Rezoning Transportation Analysis

Petition Number: 2020-112

Date	Description
09-11-20	First Review (EL)
04-15-21	Second Review (EL)
8-25-21	Third Review (BB)
9-21-21	Fourth Review (BB)
10-15-21	Fifth Review (BB)
10-28-21	Sixth Review (BB)

PROPOSED PUBLIC ROAD D

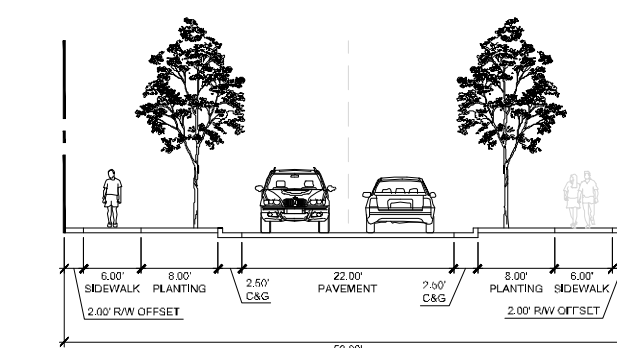
The petitioner has agreed to construct a 12-foot multi-use path along the site's frontage of IBM Drive and an east-west roadway connection (Proposed Public Road "D"). Site plan revisions are needed to address the required 6-foot bike lane on Proposed Public Road "D". Further details are listed below.

5. **Outstanding (Site plan dated 8/16/21):** Revise "Proposed Public Road D" cross-section to include a 6' bike lane. The site plan and conditional note(s) need to establish a street connection, as shown below, according to the proposed avenue cross-section that is recommended within the University Research Park Area Plan. Refer to pages 38 and 41.
